**From:** bakerasso [REDACTED]  
**Sent:** 18 Decem [REDACTED]  
**To:** Iqraa Malik  
**Subject:** RE: Request for further information FP/240/20/HH  
**Attachments:** We sent you safe versions of your files; 2008.form\_1\_cil\_additional\_information.pdf; 2008.01A.pdf; 2008.02A (2).pdf

DATE	DRAWN	SCALE	NUMBER
NOV 2020	A	1:50	2008.01A

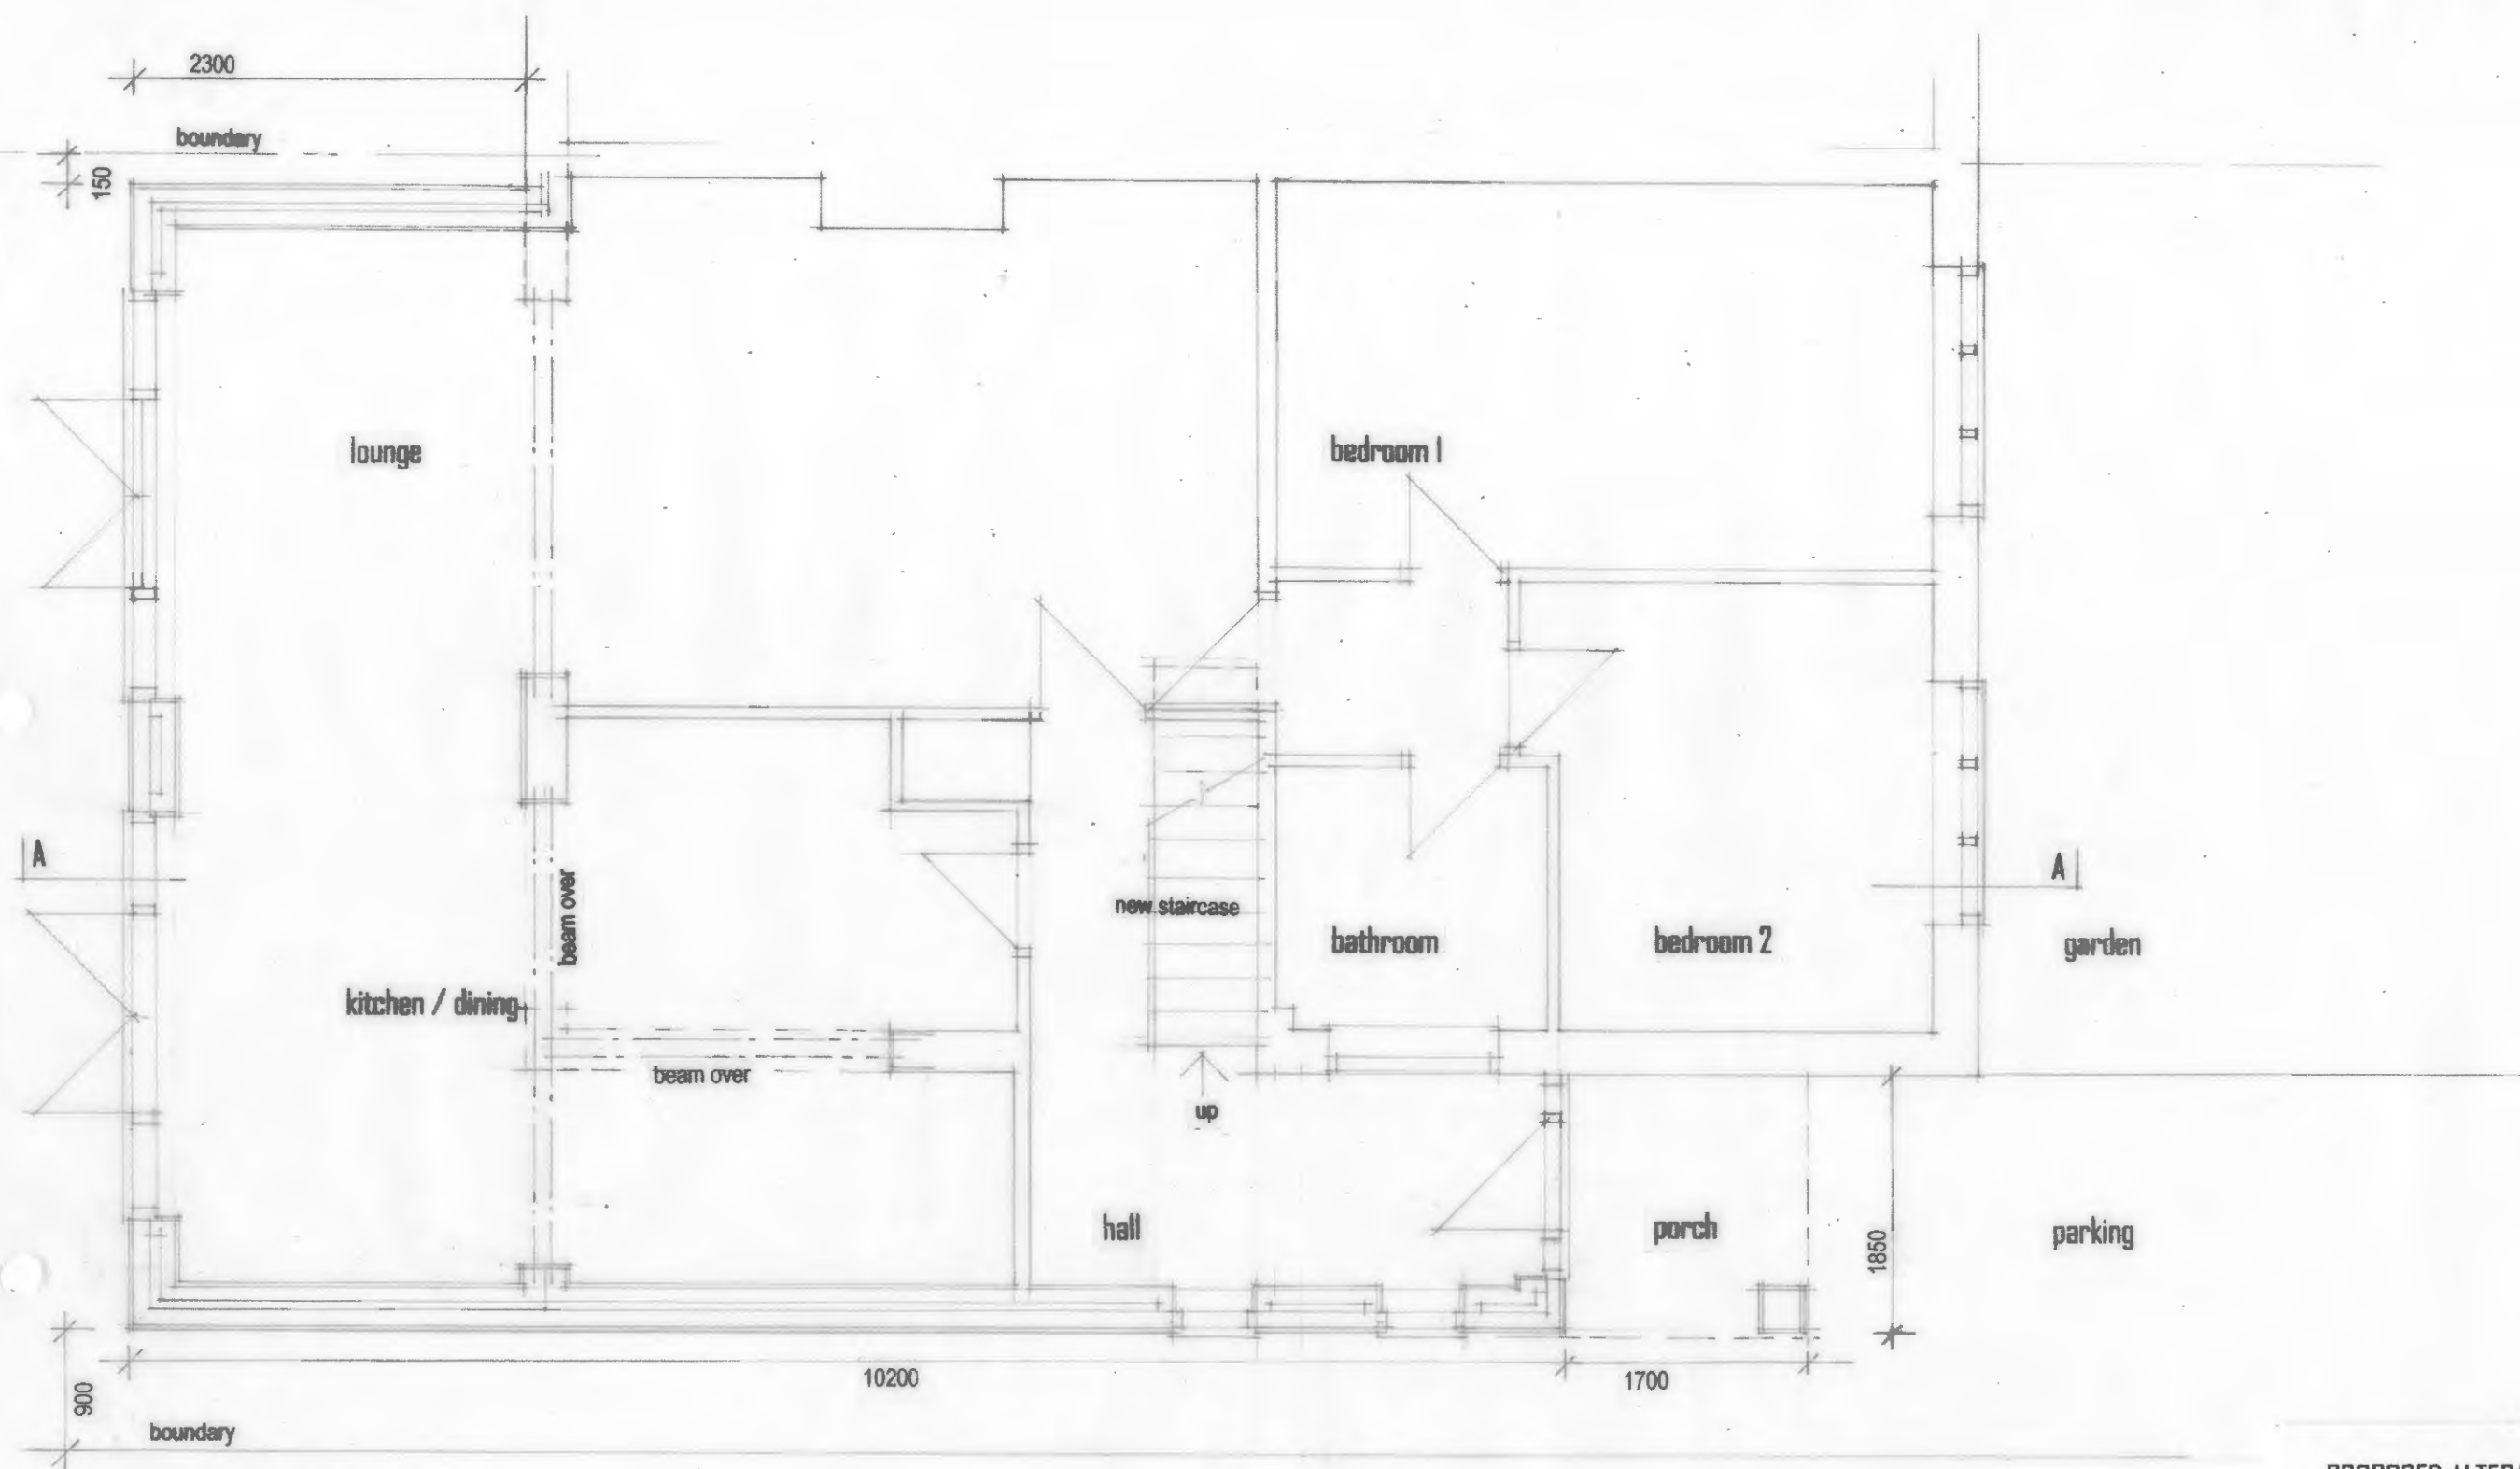
Additionally, the scale bars on the floor plans do not measure to scale. I have attached a screenshot below. Please amend.

Dear Ms Malik,  
Thank you for your message.  
As requested I attach the CIL form.  
I apologise for the wrong scale bars on drawings 2008/1A and 2A, these have been corrected and are attached.  
Kind regards,  
Alan Baker.

The proposed floor plans are to 1:50 scale, when printed at A3 size.
